City of Portland, Maine - Building or Use Permit Application

Permit No: 06-1231	Issue Date:	CBL: 259 E004001
-----------------------	-------------	---------------------

Location of Construction: 16 DAVID RD	Owner Name: HIPSHER SALLY L & STEPHEN	Owner Address: 16 DAVID RD	Phone:
Business Name:	Contractor Name: property owner	Contractor Address: Portland	Phone:
Lessee/Buyer's Name	Phone:	Permit Type: Alterations - Dwellings	Zone: R3

Proposed Project Description: Dormer for new bathroom	FIRE DEPT: <input type="checkbox"/> Approved <input checked="" type="checkbox"/> Denied <i>W/A</i>	INSPECTION: Use Group: <i>R-3</i> Type: <i>SB</i> <i>IRC 2003</i>
	Signature:	Signature:
	PEDESTRIAN ACTIVITIES DISTRICT (P.A.D.)	
	Action: <input type="checkbox"/> Approved <input type="checkbox"/> Approved w/Conditions <input checked="" type="checkbox"/> Denied	
	Signature:	Date:

R3 - lot size 6553 sq ft
 front - 25' req. ~~21~~ 21 given
 rear - 25' req. OK
 side - 2 story - 14 req. - total of 32' OK
 for left
 23 on right.

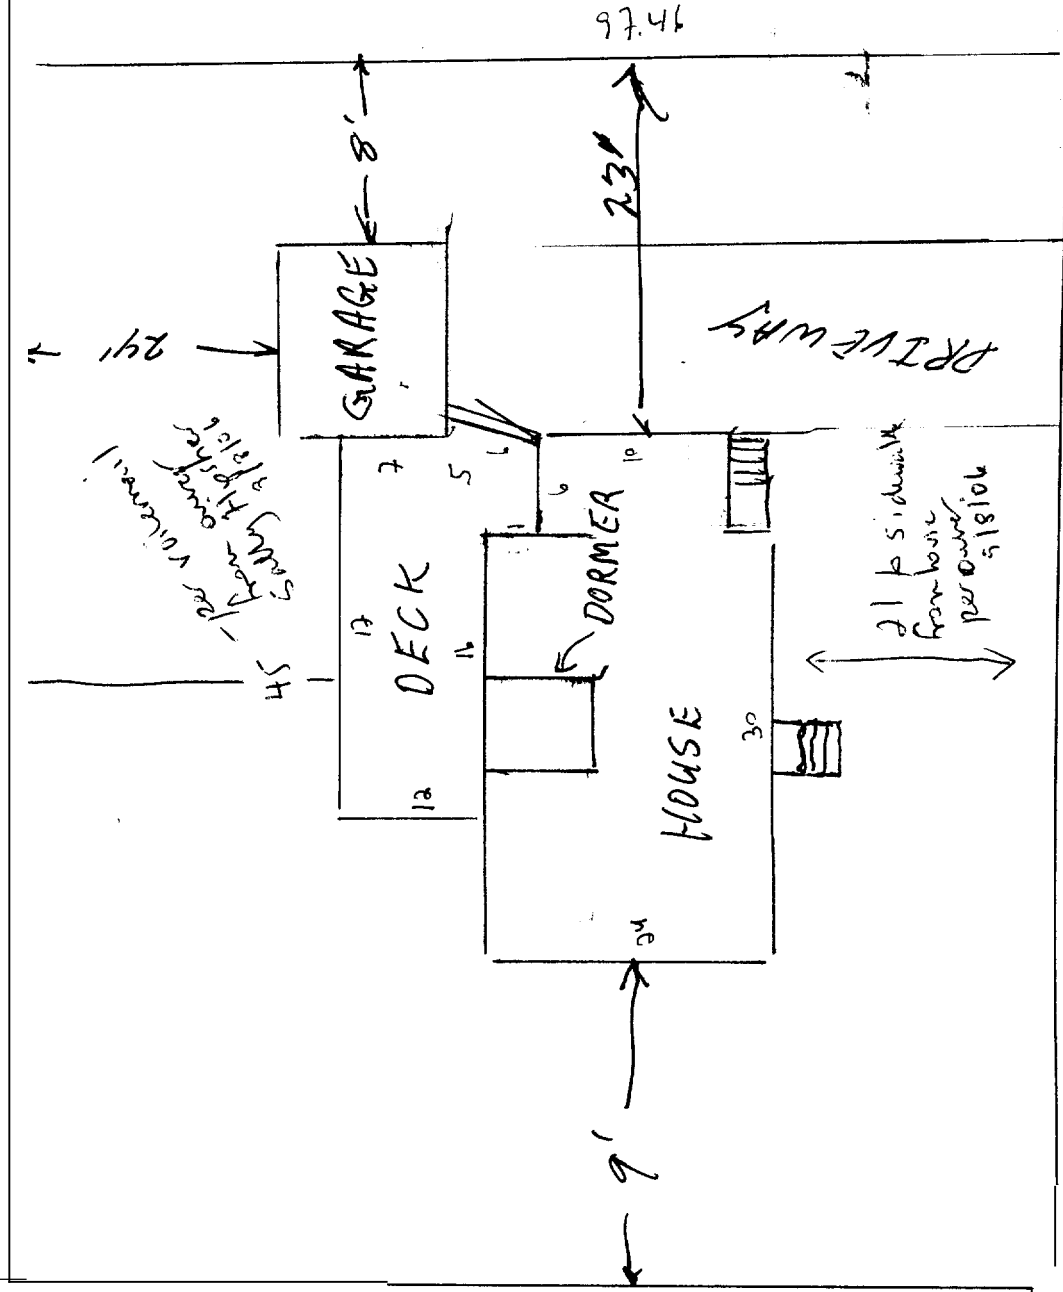
Note: House does not meet front setback of 25'. Section 14-436(b) allows an 80% increase. The dormer adds 46.6 s.f out of the allowable 812 s.f. increase, so it uses 6% of allowable 80% increase. **Ok to Issue:**

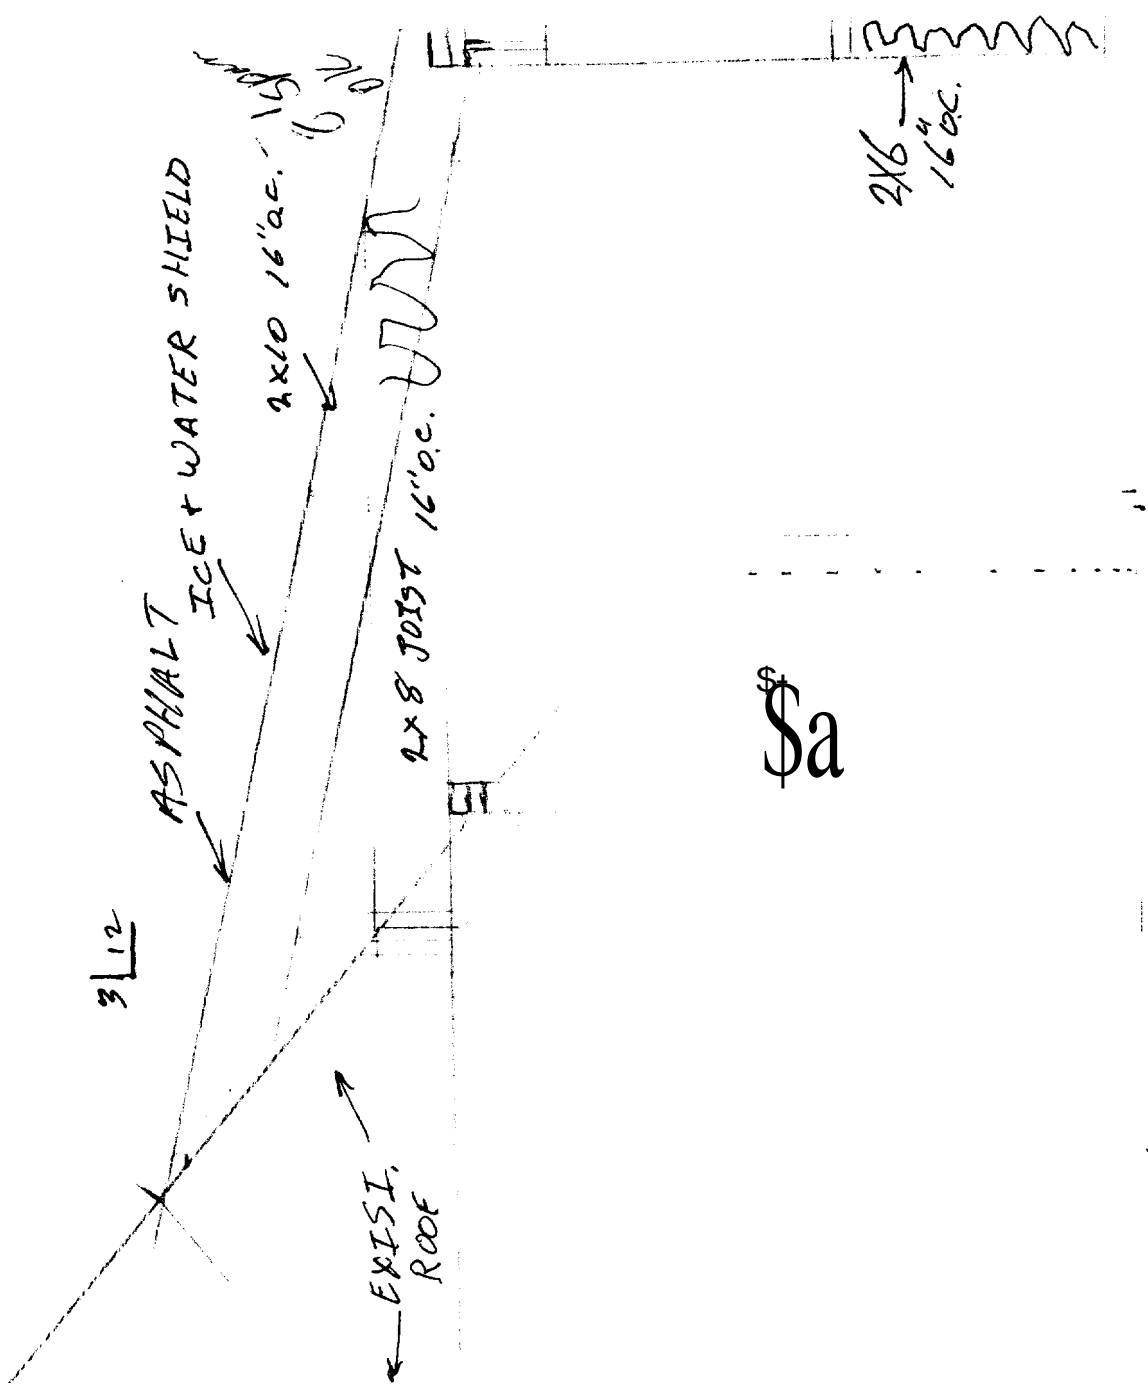
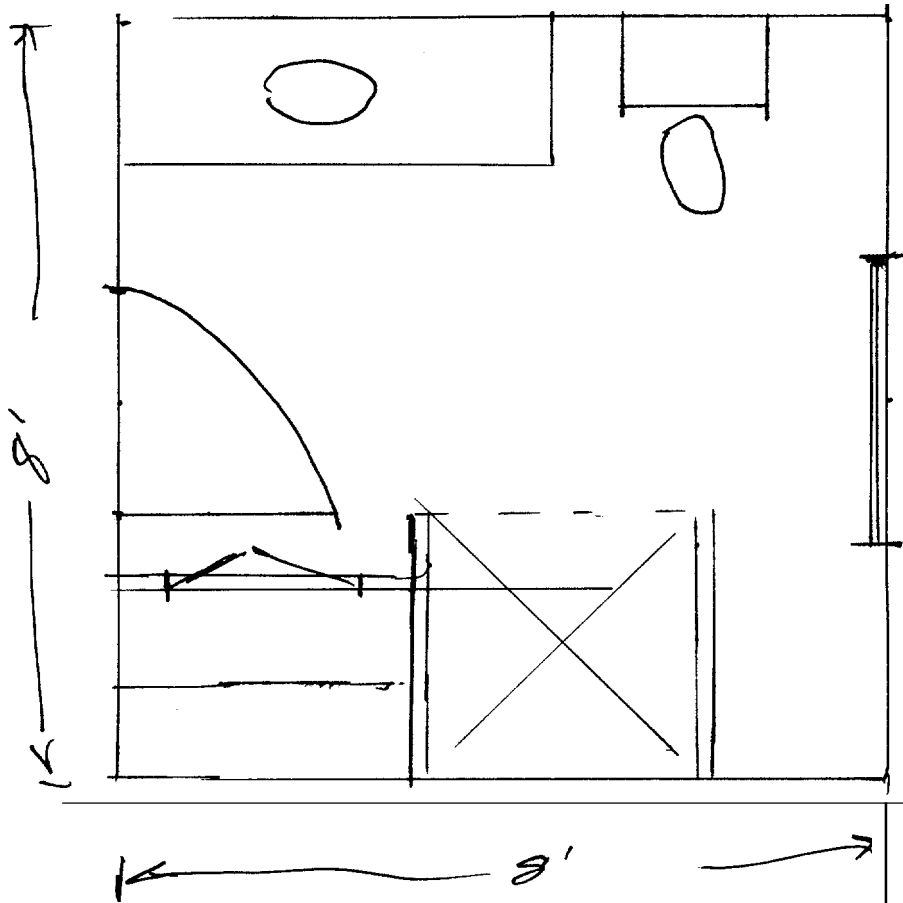
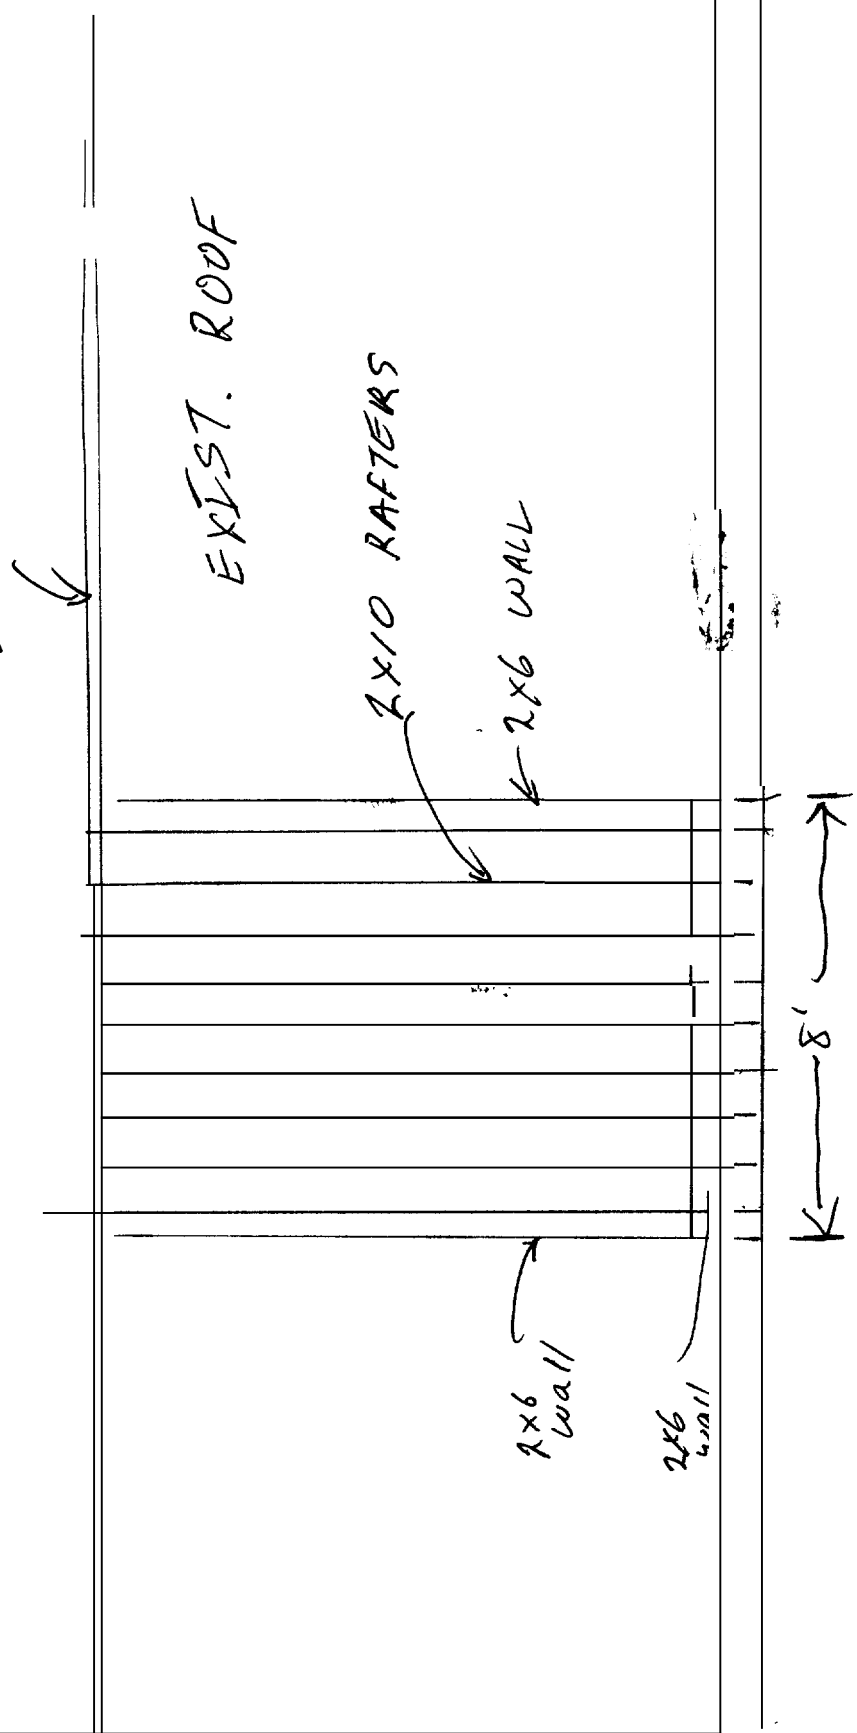
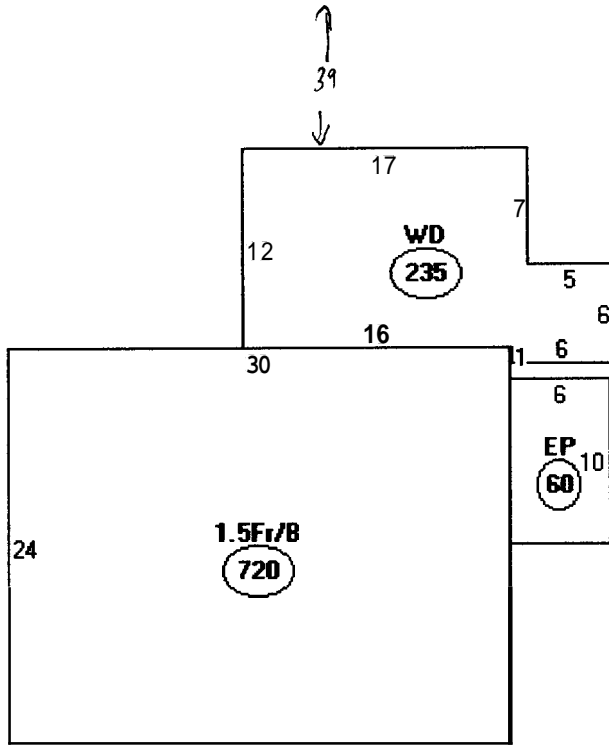
- 1) Separate permits are required for any electrical, plumbing, or HVAC systems. Separate plans may need to be submitted for approval as a part of this process.
- 2) The minimum header size over the window must be 2- 2"x 6"s.
